# Rezoning Transportation Analysis

Petition Number: 2021-081

Date	Description
08-02-21	First Review (LH)
08-26-21	Second Review (BKB)

RZ-1

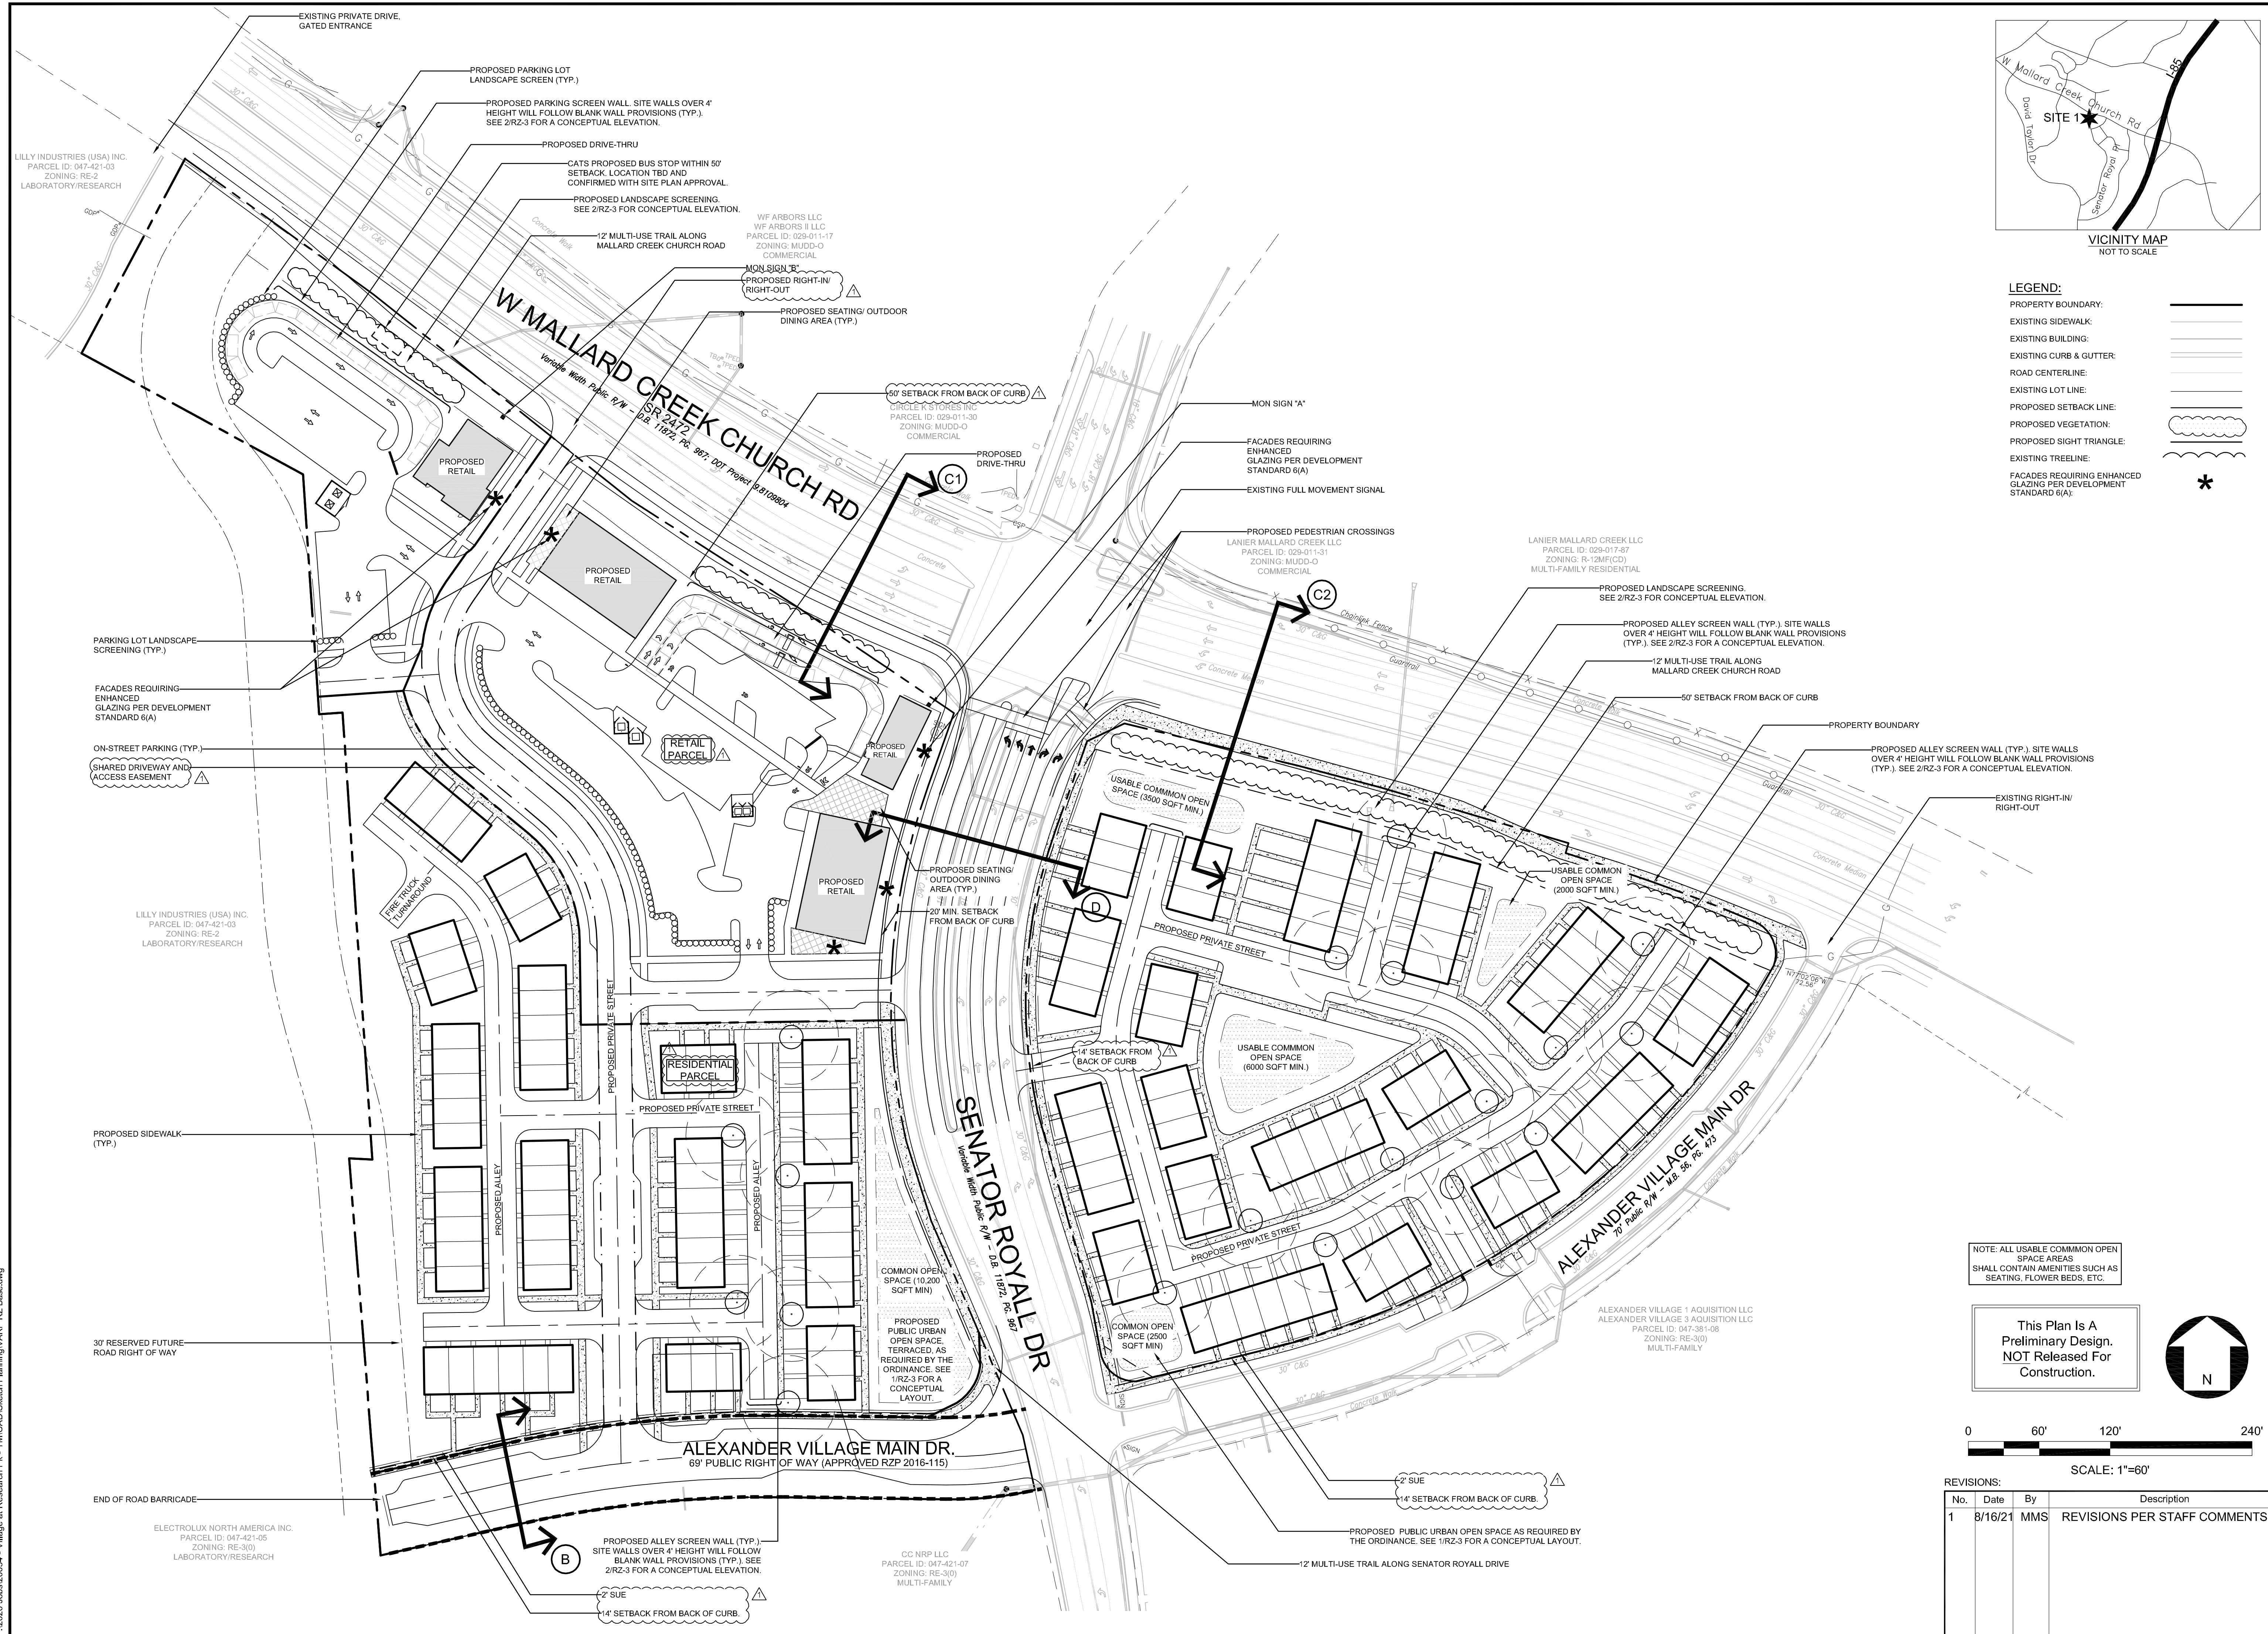
- ~~**Curbline:** The proposed zoning district has a setback measured from back of the existing or proposed future curbline.~~
- Traffic Study:**  
Since traffic impacts have not changed for this site the previous rezoning petition, a Traffic Impact Study (TIS) is not necessary for the complete review of this petition.
- Update to Comments (Site Plan dated 08-16-21):** Add conditional note to require the right turn lane from Mallard Creek Church Road into the site:

RZ-3

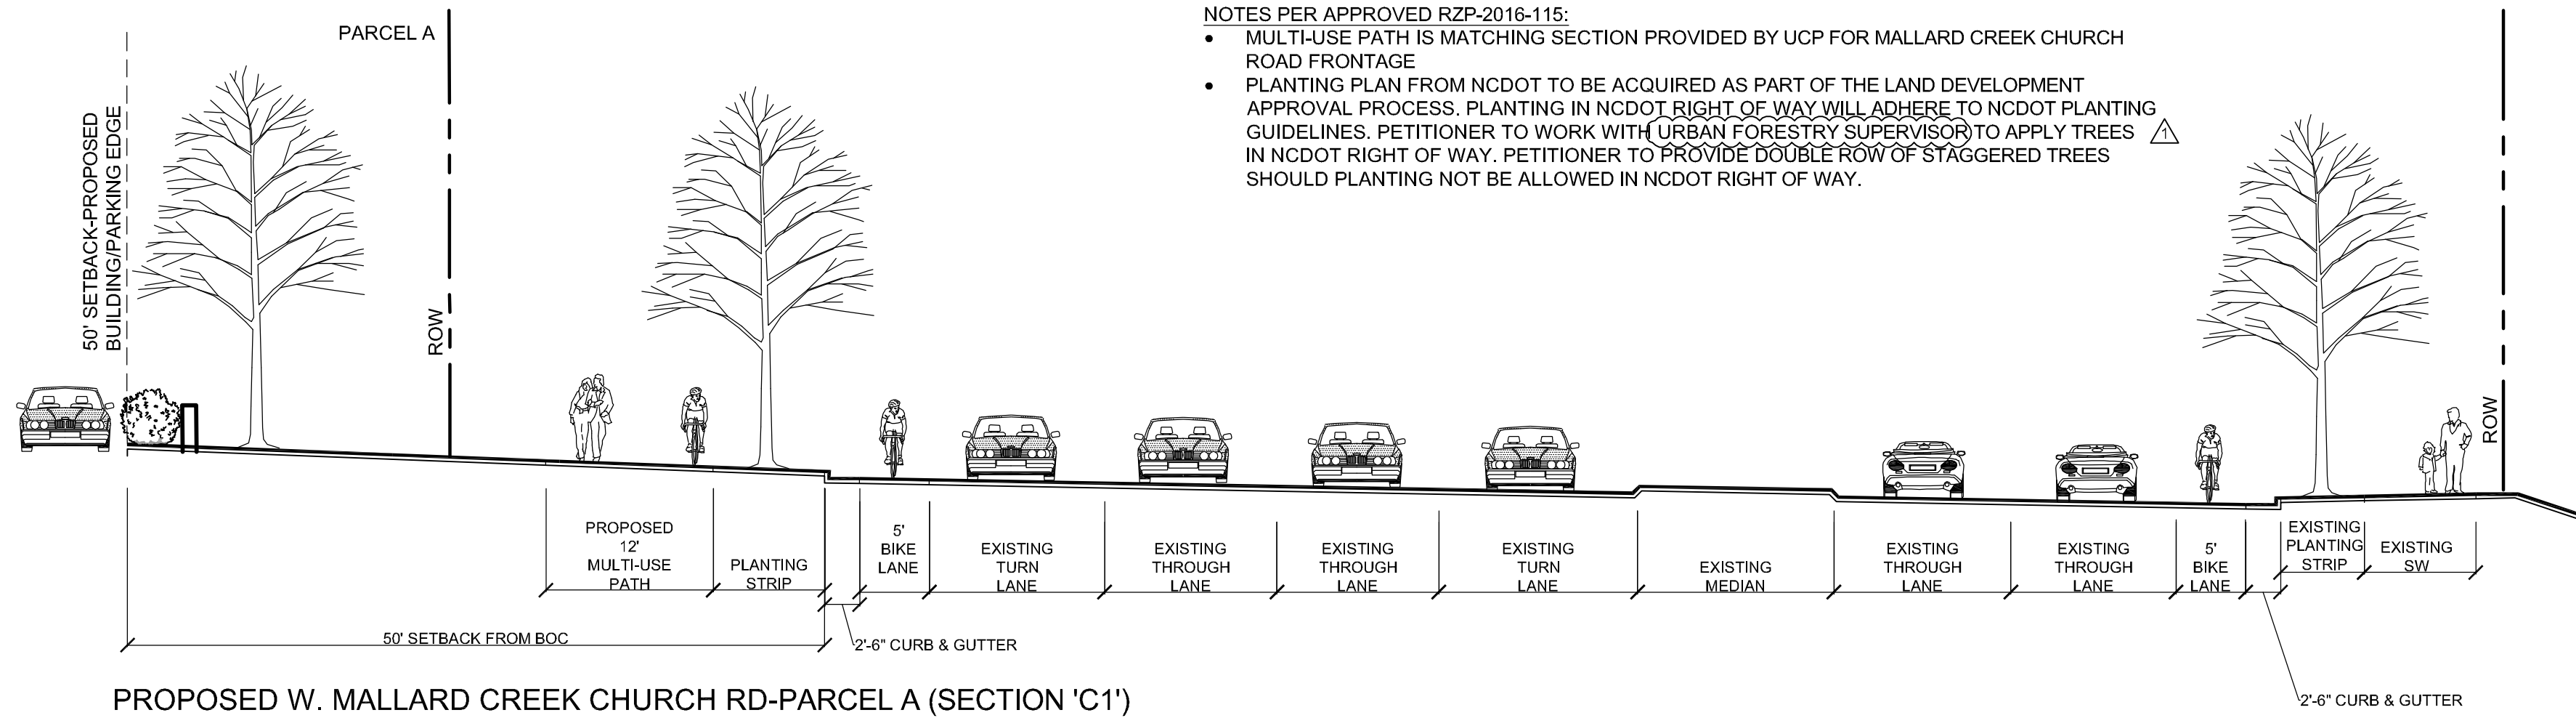
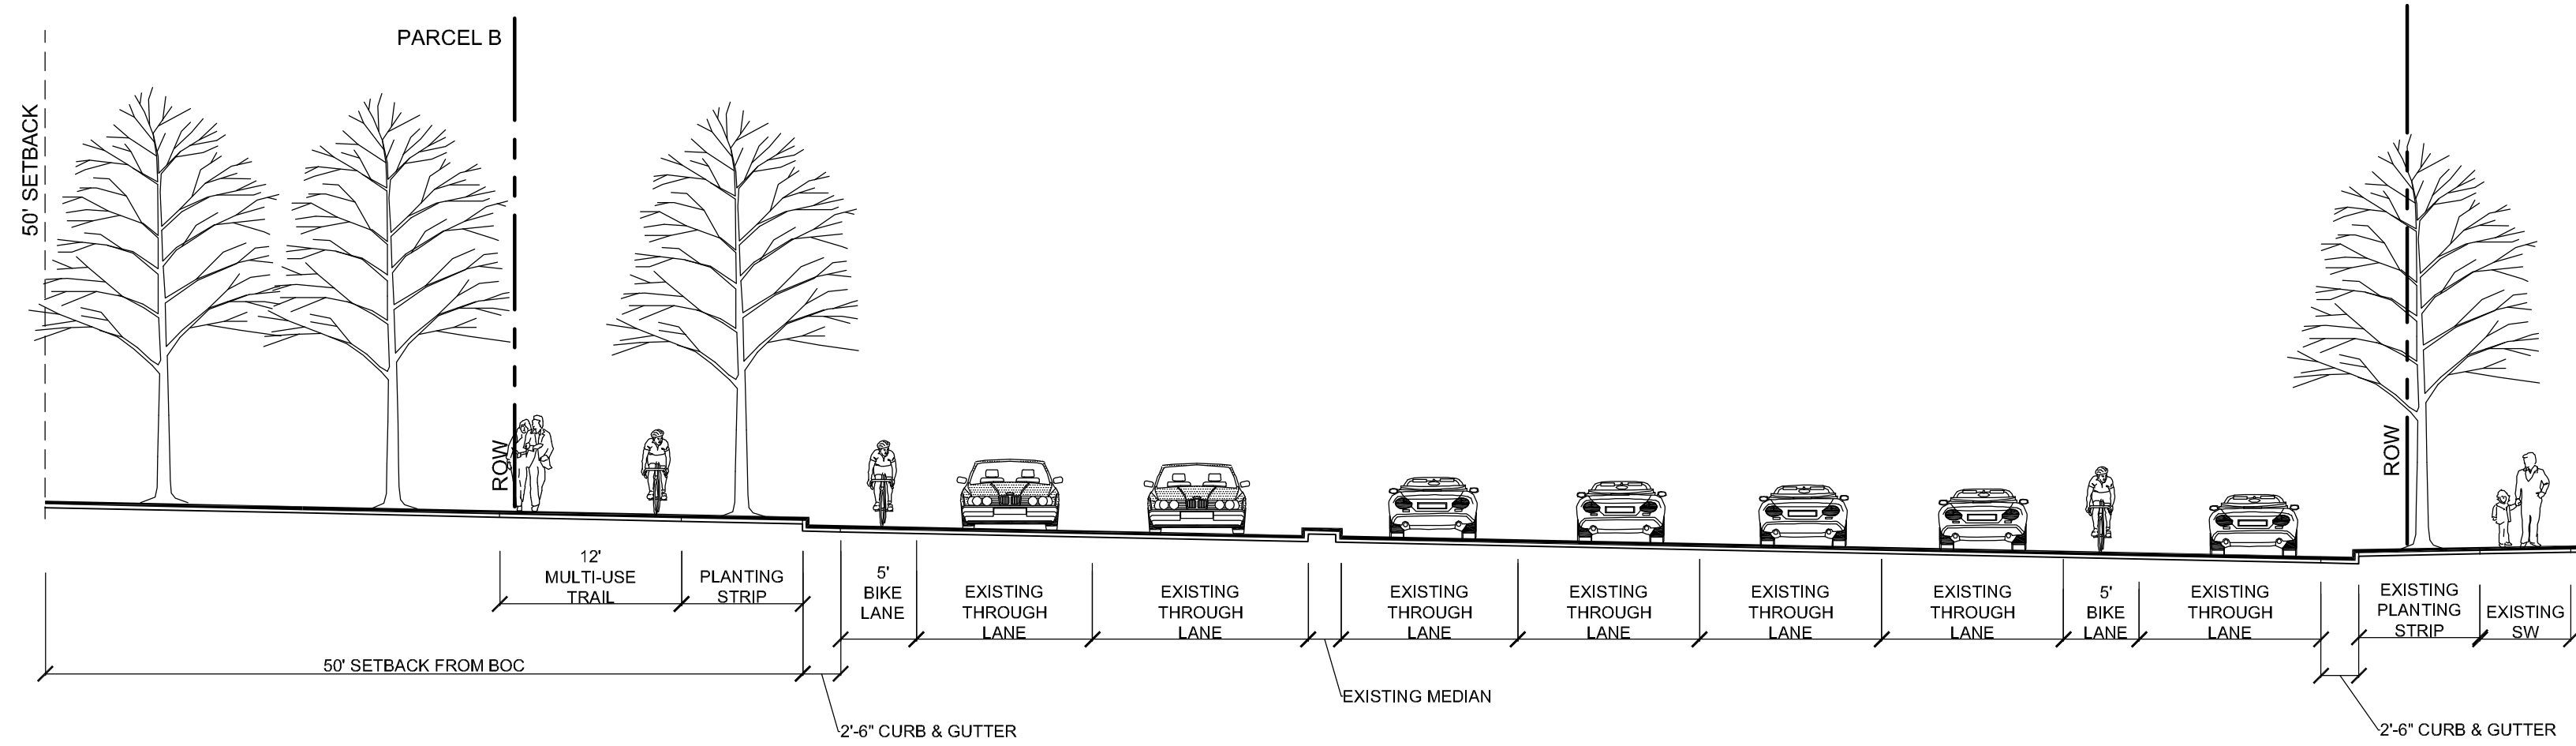
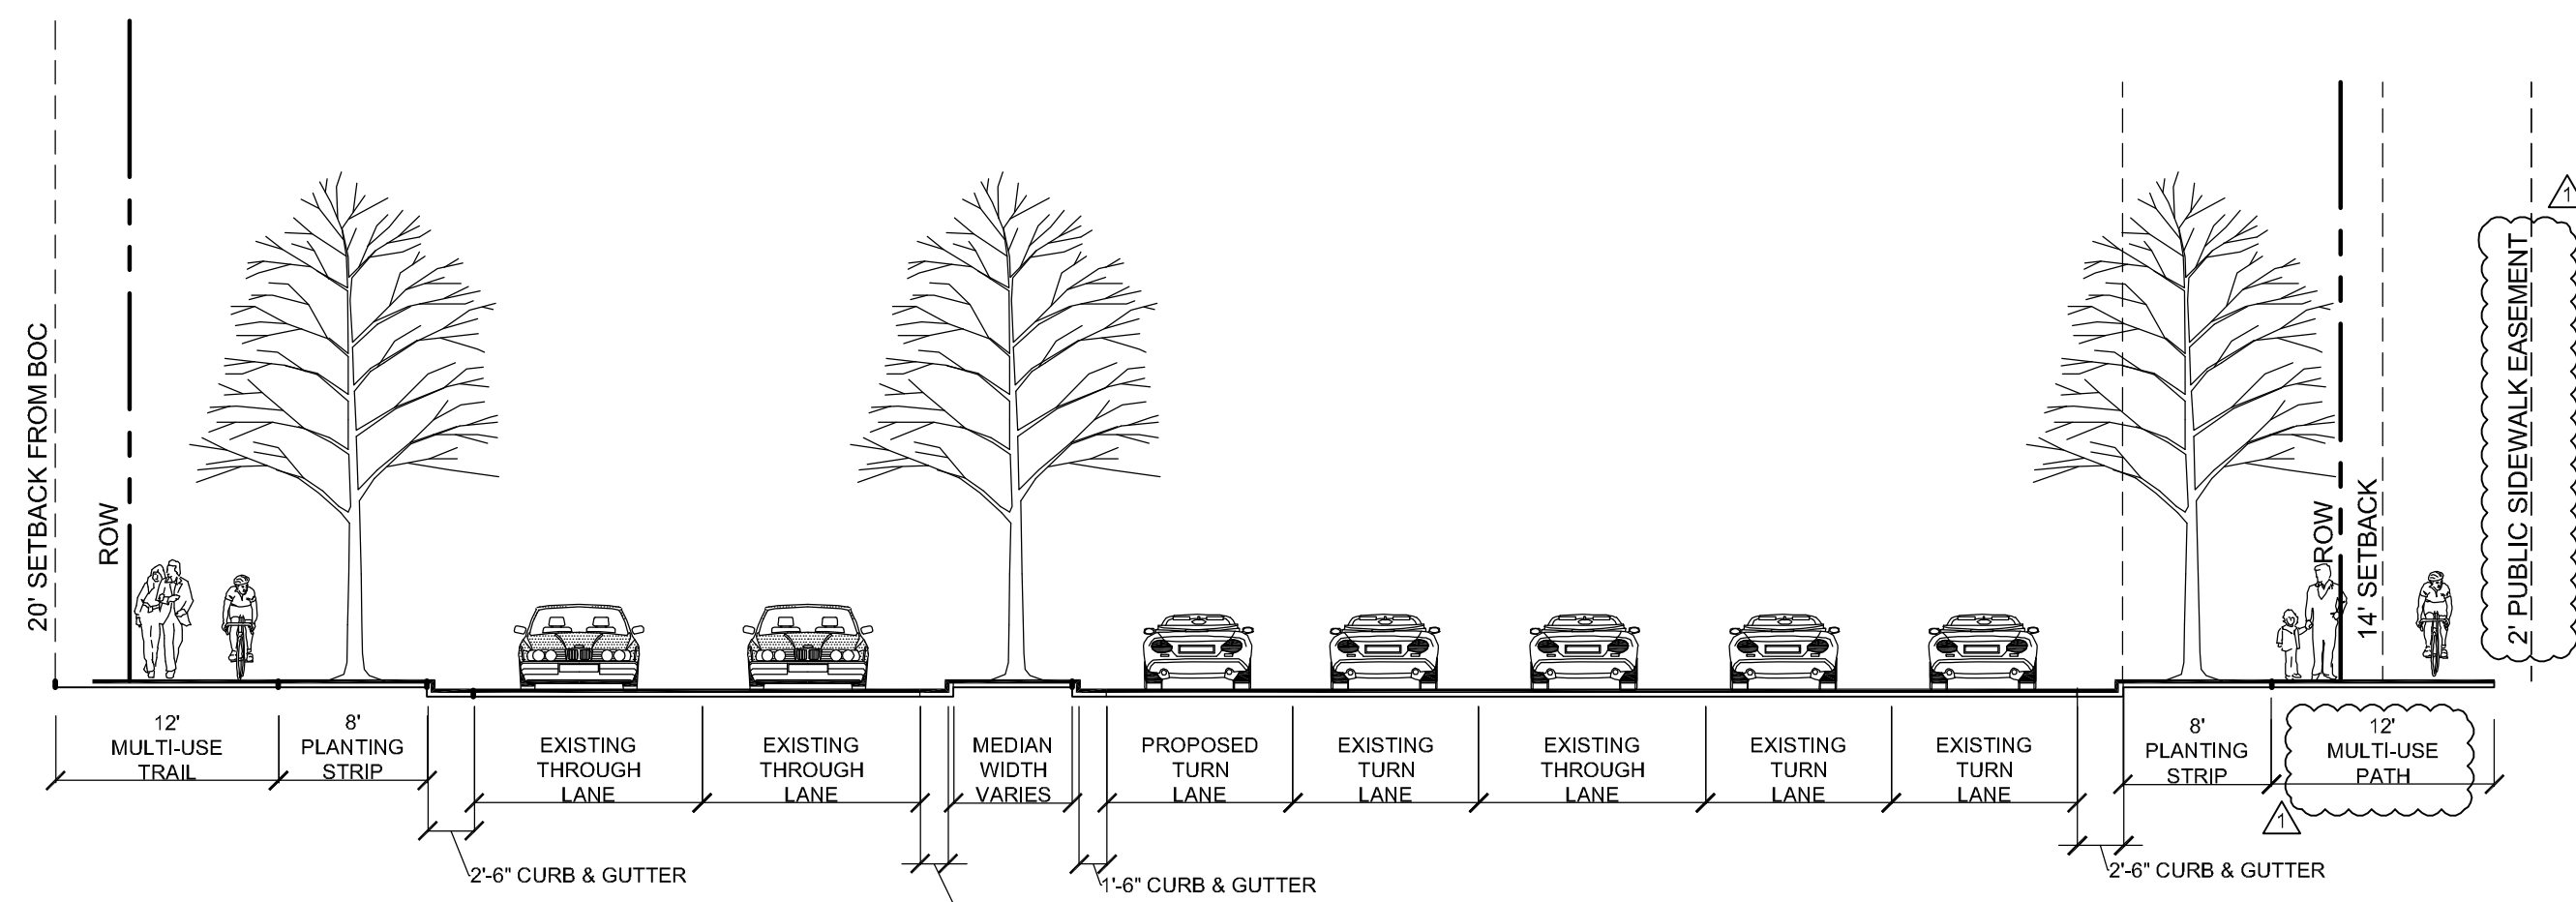
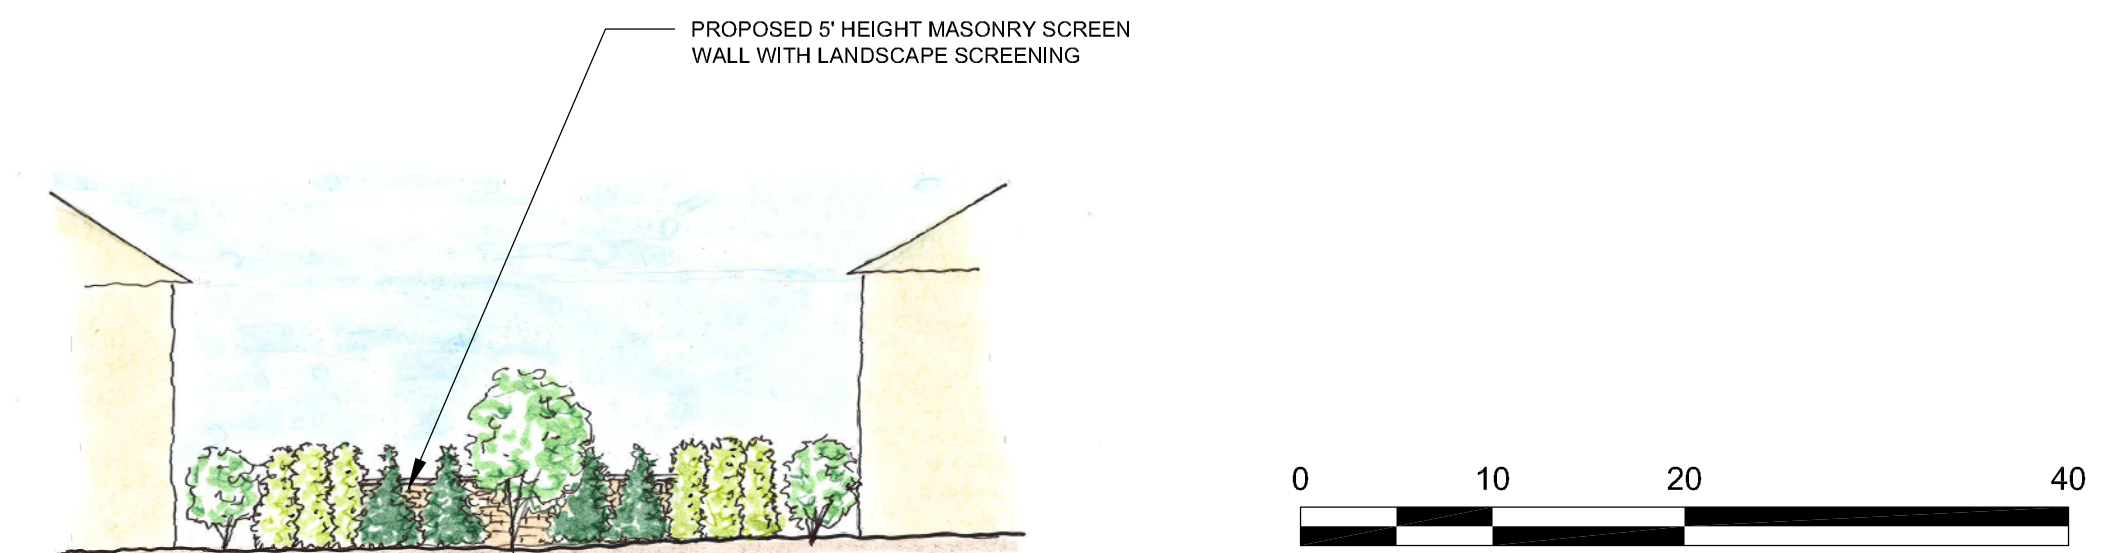
- Update to Comments (Site Plan dated 08-16-21):** Update Note 3 for Transportation notes to reflect current bicycle and pedestrian accommodations shown in site plan and typical sections. Modify verbiage to reflect 8 foot planting strip and 8 foot sidewalk on the site's frontage of Alexander Village Main Drive (remove Senator Royall Drive from that sentence). Specify 12 foot multi-use path on both sides of Senator Royall Drive.
